## Letter of Intent

Project Name: Woodford Manufacturing Co.

### Request and Justification

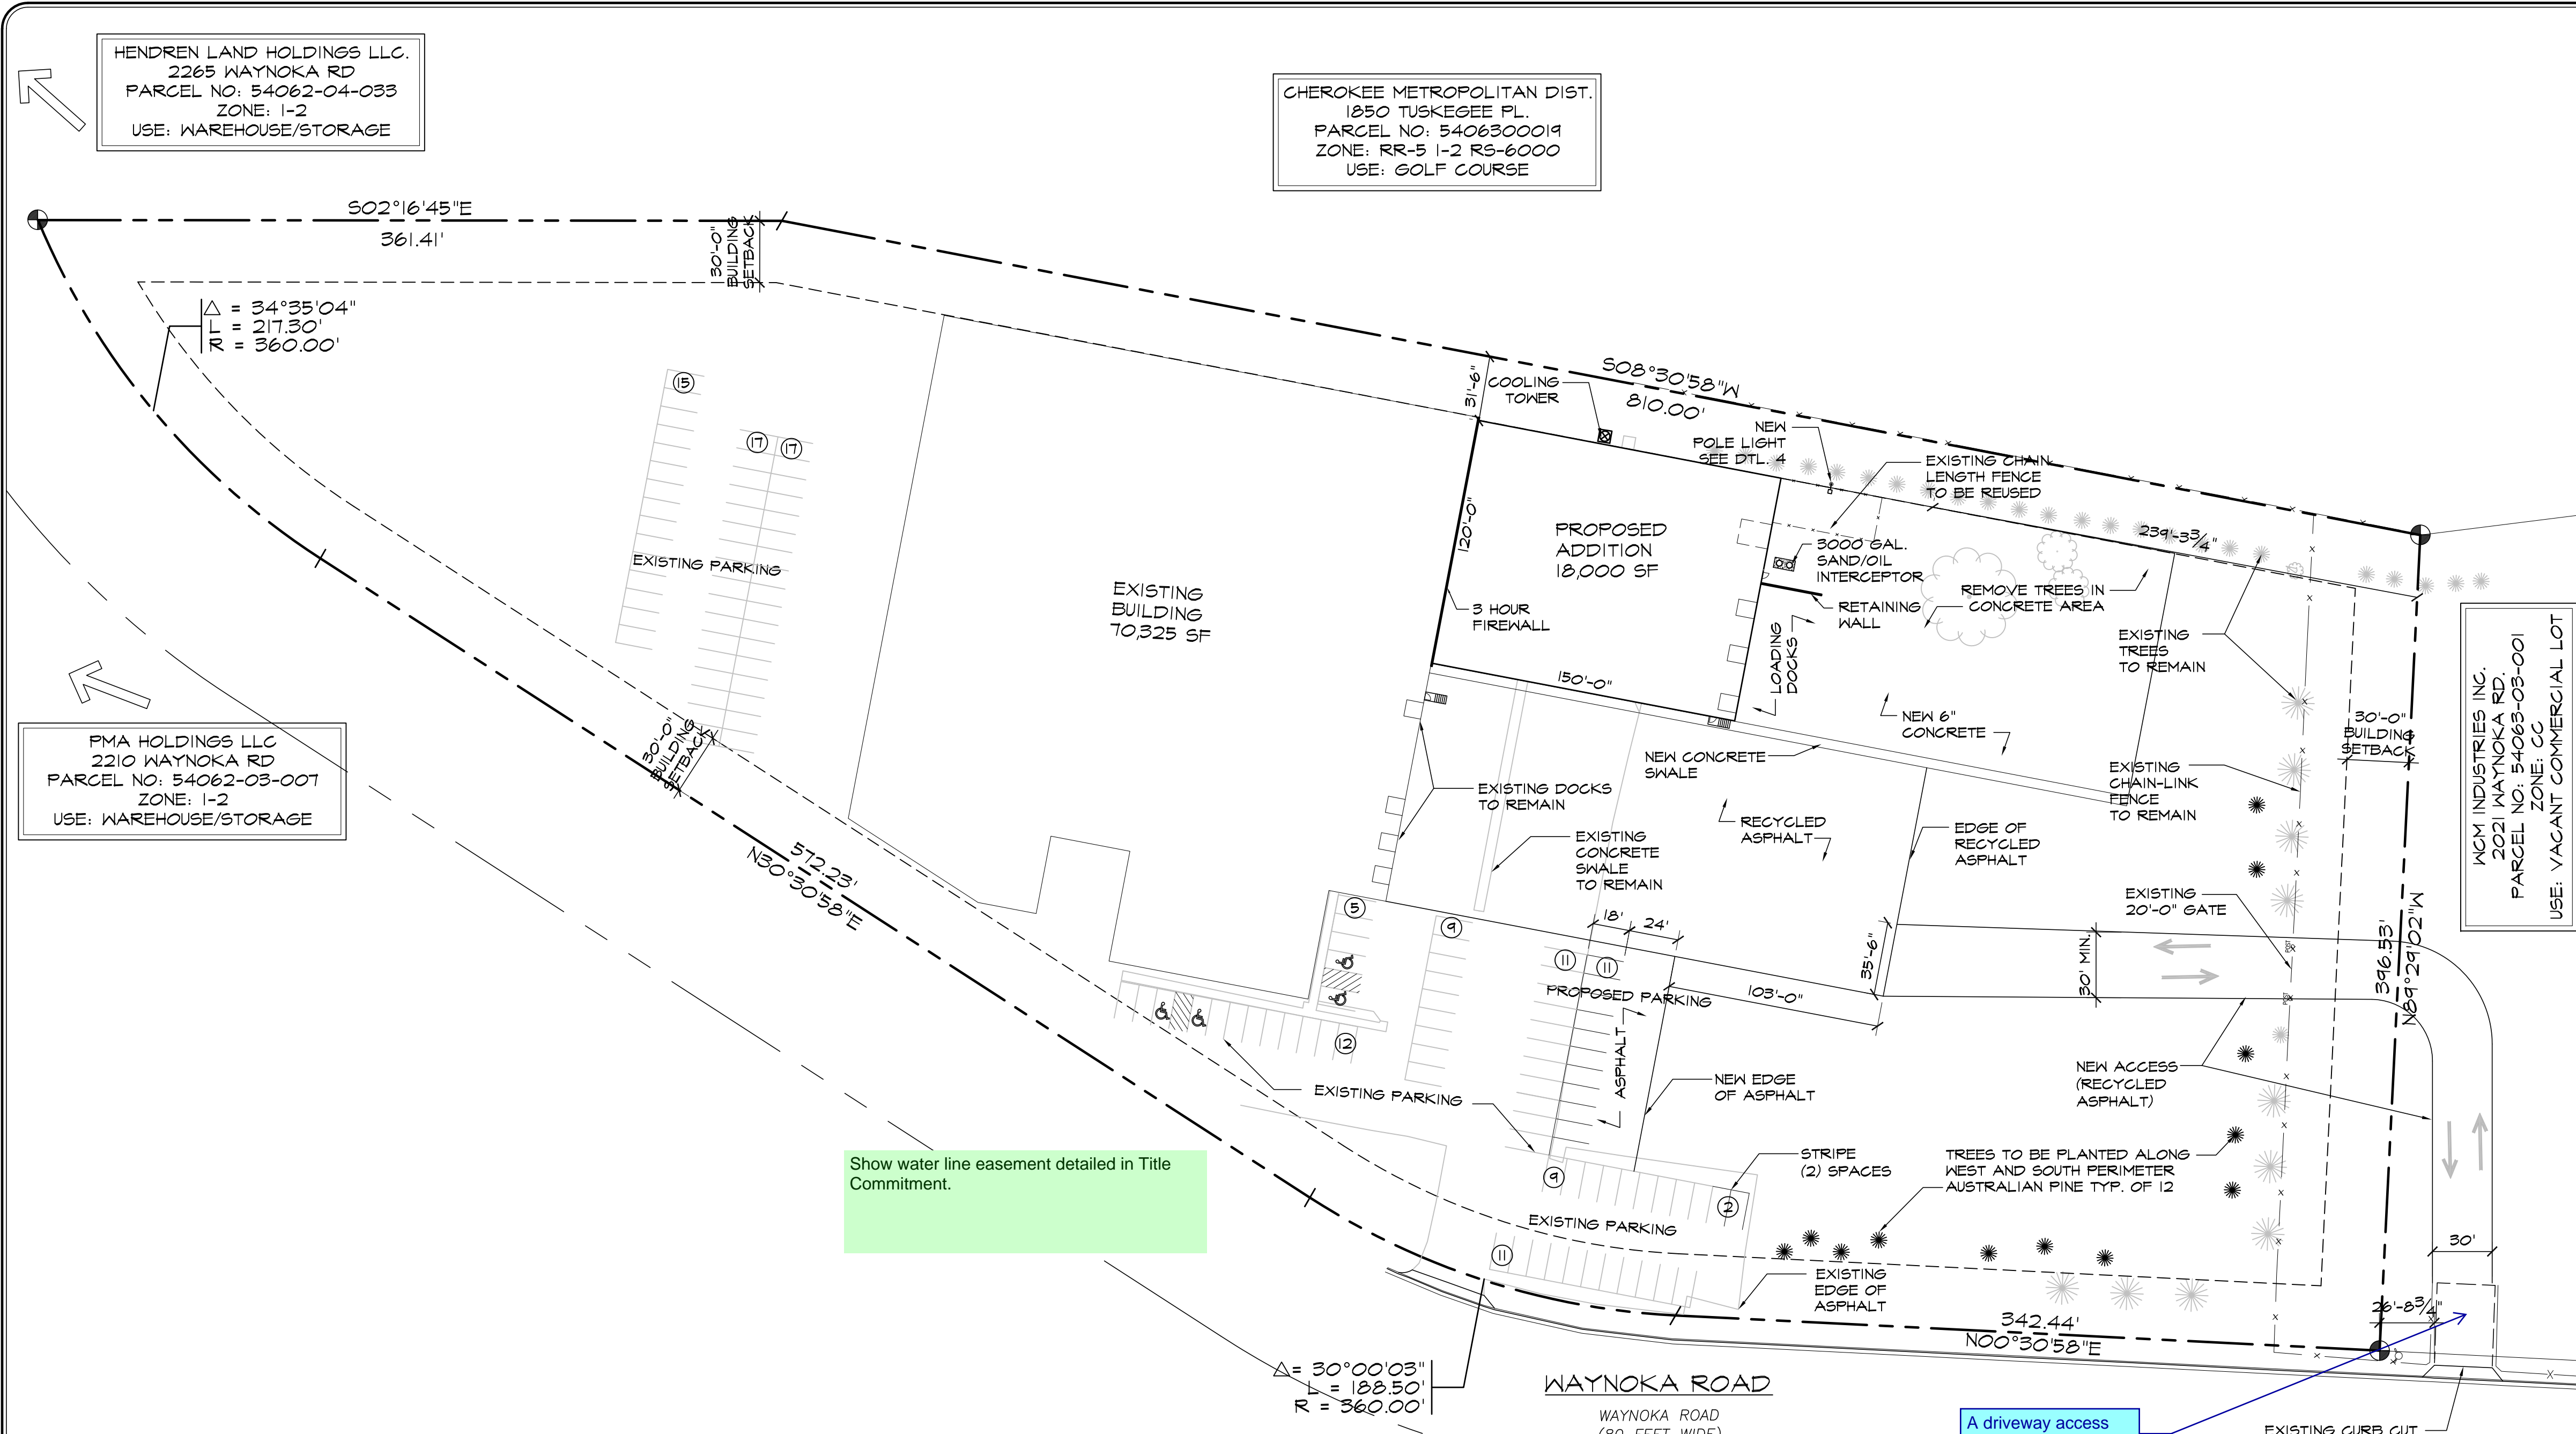
Include any alternative requests and justify reasons as to why landscaping/buffering may not apply.
